I am writing as a parent of a child that attends Darlington Public School regarding the proposed development by the University of Sydney, MP 07_0158 – Abercrombie Street Precinct, Syd Uni. Darlington Public School is an inner city school servicing the suburbs of Chippendale, Darlington and parts of Redfern. The school is directly adjacent to the western border of the project.

Drawing title
GROUND FLOOR PLAN

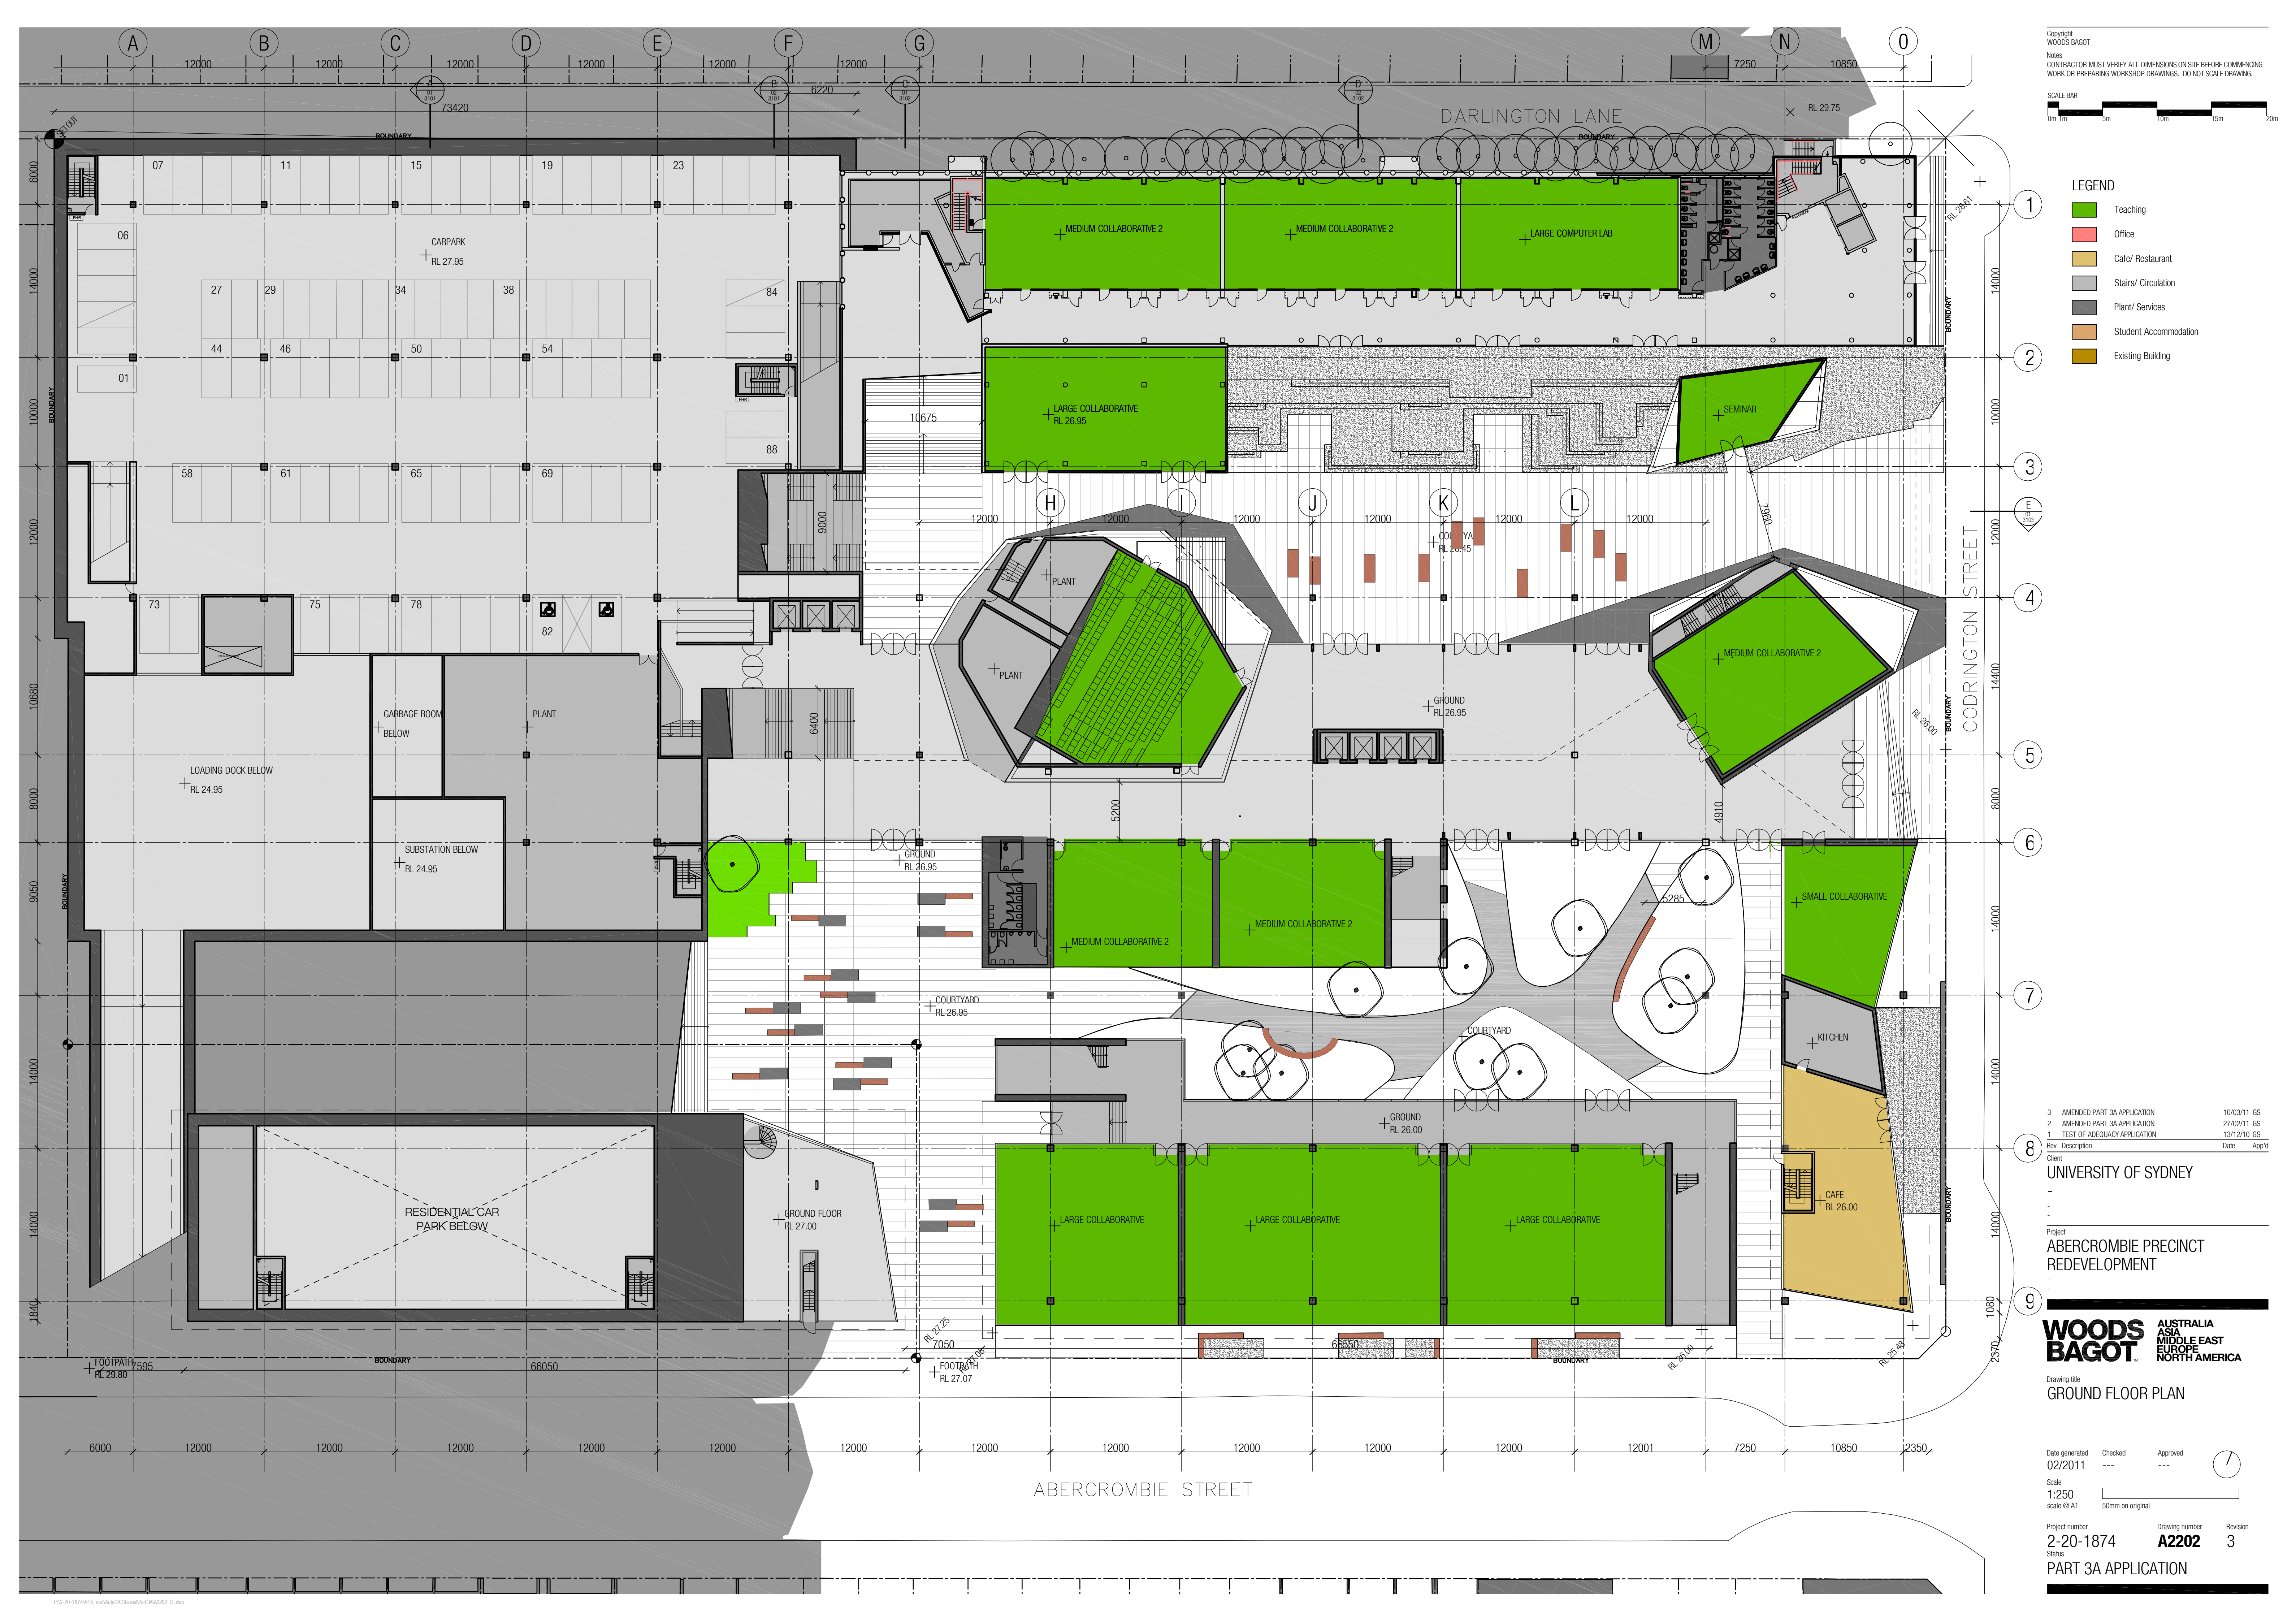
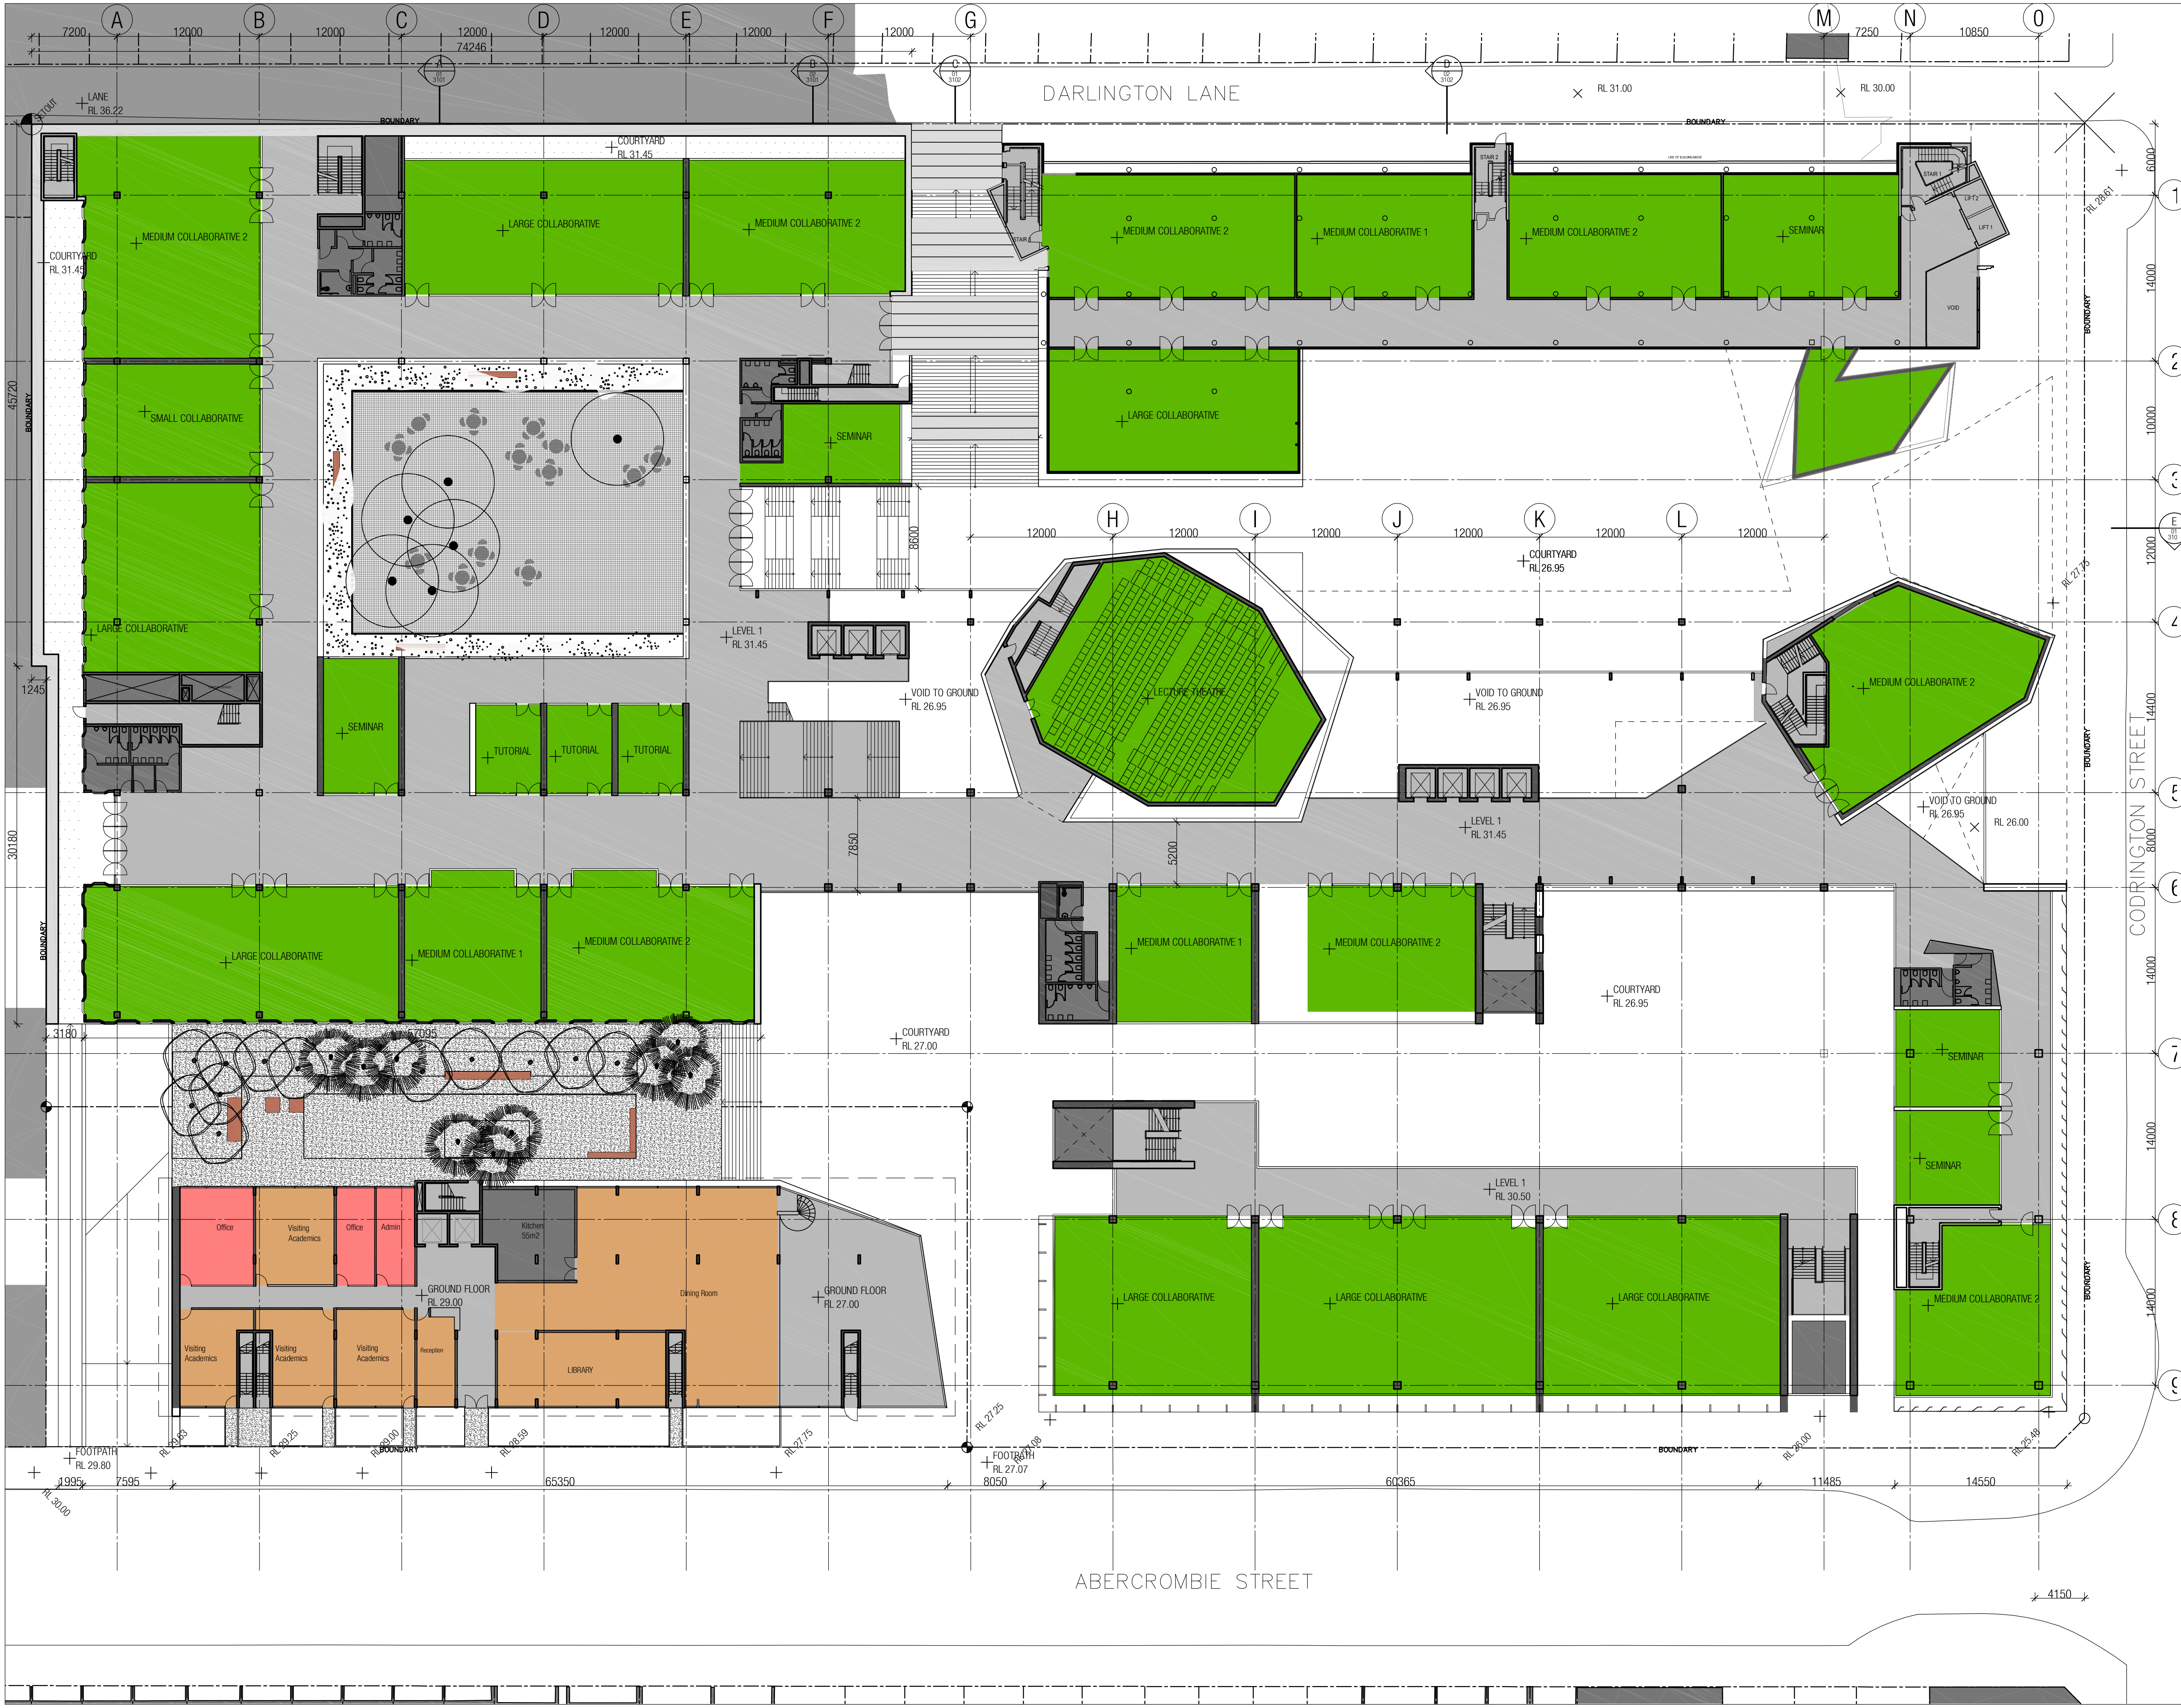
The proposed access point for the site is on Abercrombie Street and is directly adjacent to the school classrooms on their North East border of the school site. Locating the access point for trucks would:

- produce unacceptable levels of noise and vibration in the school classrooms that border that entrance – year 2, 4, 6 and both kindergarten classes. This is also particularly significant for the 2 kindergarten classrooms which face the development to the north with only glass panels and glass doors on that side.
- create an unsafe corridor for school children and parents that walk, or ride to school along Abercrombie Street (north side). This includes many unaccompanied but young children entering and leaving the school.
- create an unsafe car drop off and pick up point on Abercrombie Street (the main drop off point at the school).
- reduce the drop off and pick up point area for numerous children who are transported by car.

As per the current development plan, the proposal calls for an underground car park to be built for the student accommodation and University staff. The car park will accommodate 185 car spots, and its entrance will be on Abercrombie Street, at approximately the same point of the construction access.

The concerns raised above about the access point to the construction site are the same for this car park access point increasing the risk to school children's safety, in an area that has already been highlighted through the respective organisations (Council, Police, and RTA). The increased traffic flows and access point are an unacceptable risk to the children who attend the school. There is no justification for this level of risk to a school community, particularly as the University has another street frontage without school or residential issues (the University being the only stakeholder for Codrington Street) and an access street internal to project (Darlington Lane).

Drawing title
SHADOW DIAGRAMS - SUMMER
SOLSTICE - DECEMBER 22

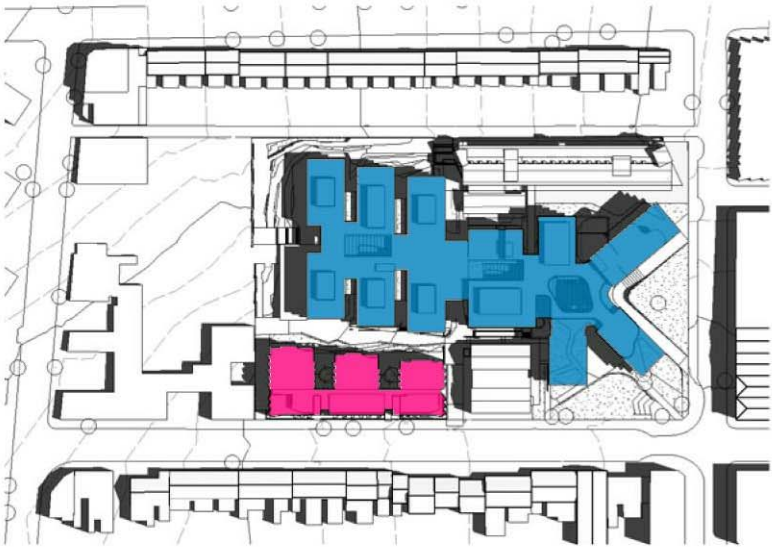
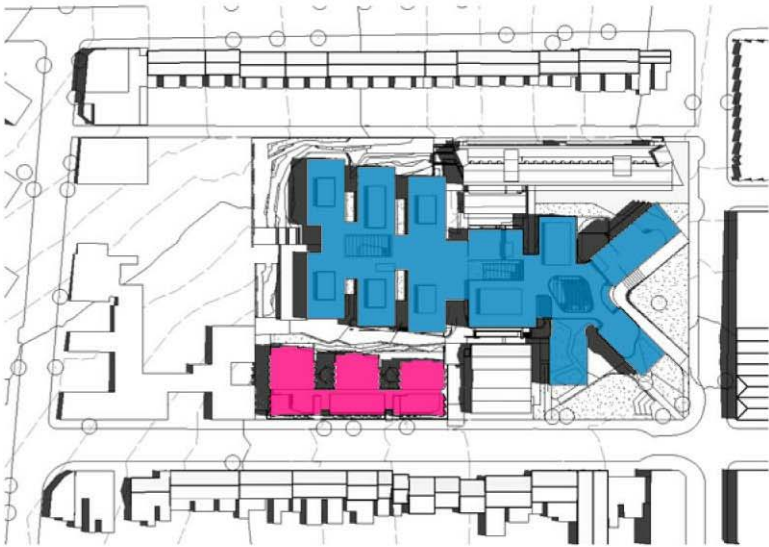
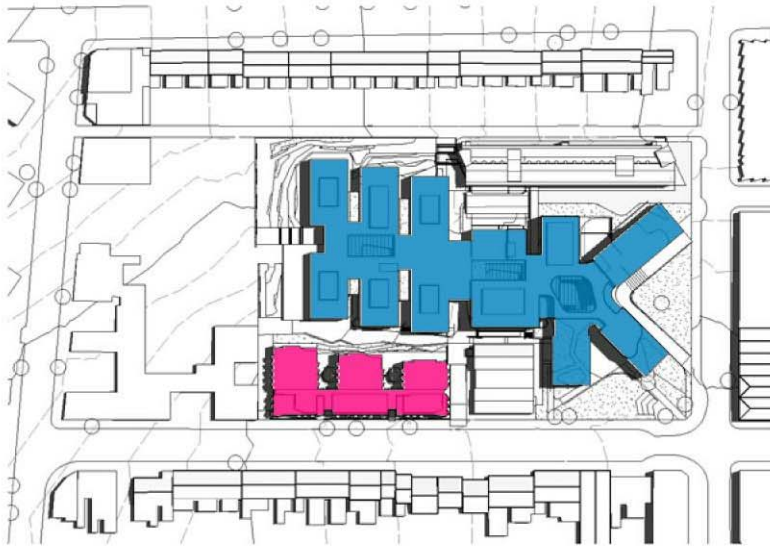
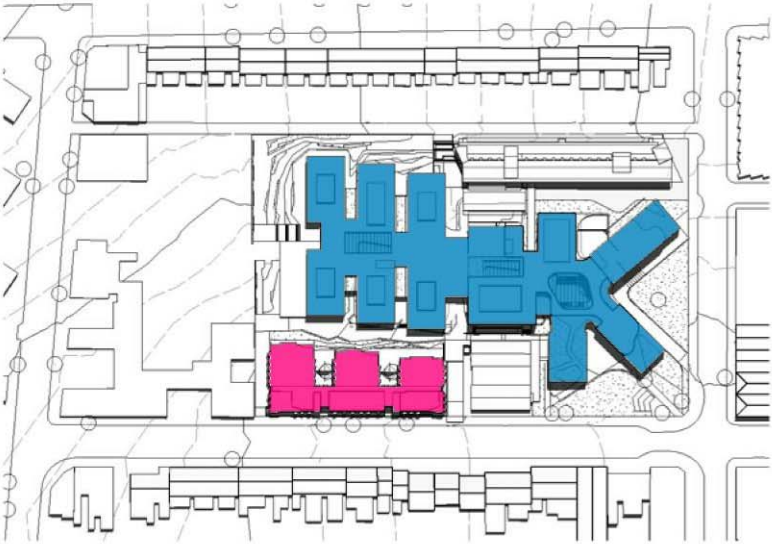
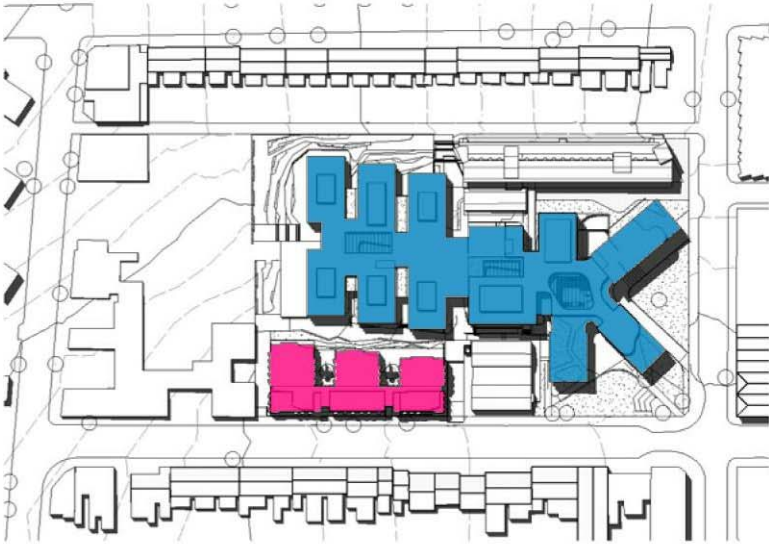
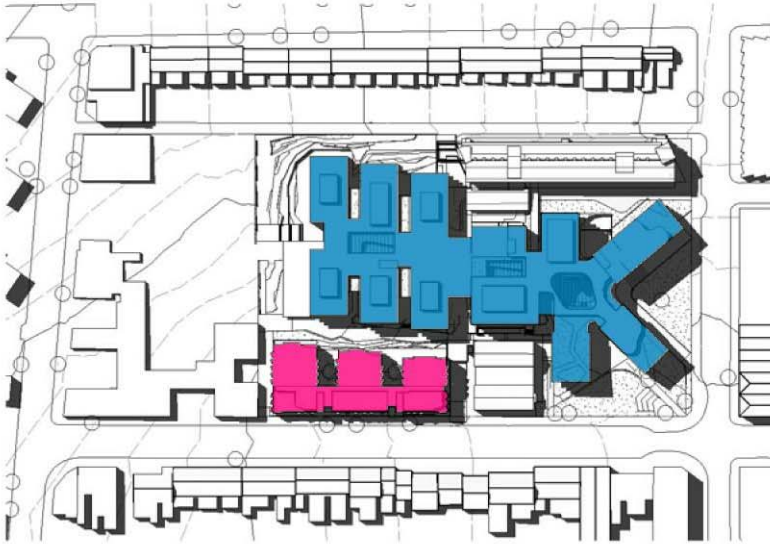
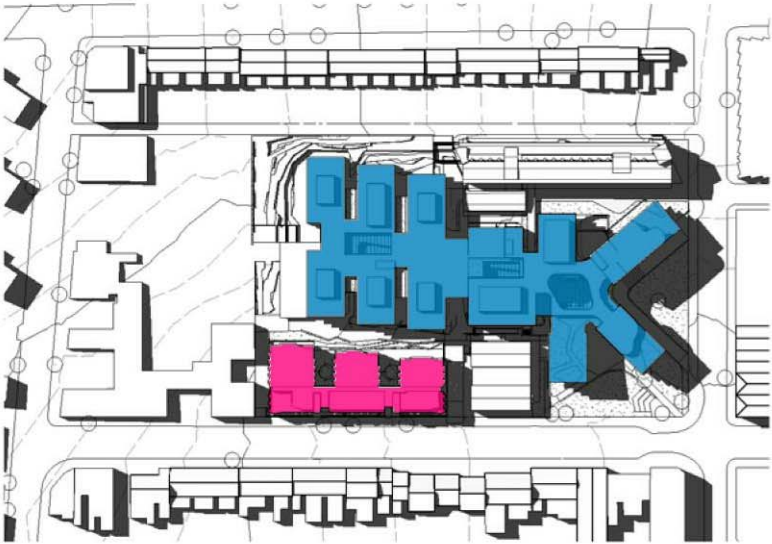
The new Business facility building will be seven stories high, and with its location in the [North West](#) corner of the school playground it will cause a large shadow effect over the majority of the playground.

What consideration has been given to this impact, and the requirement for natural light for the play areas, making it a [suitable](#) area to play?
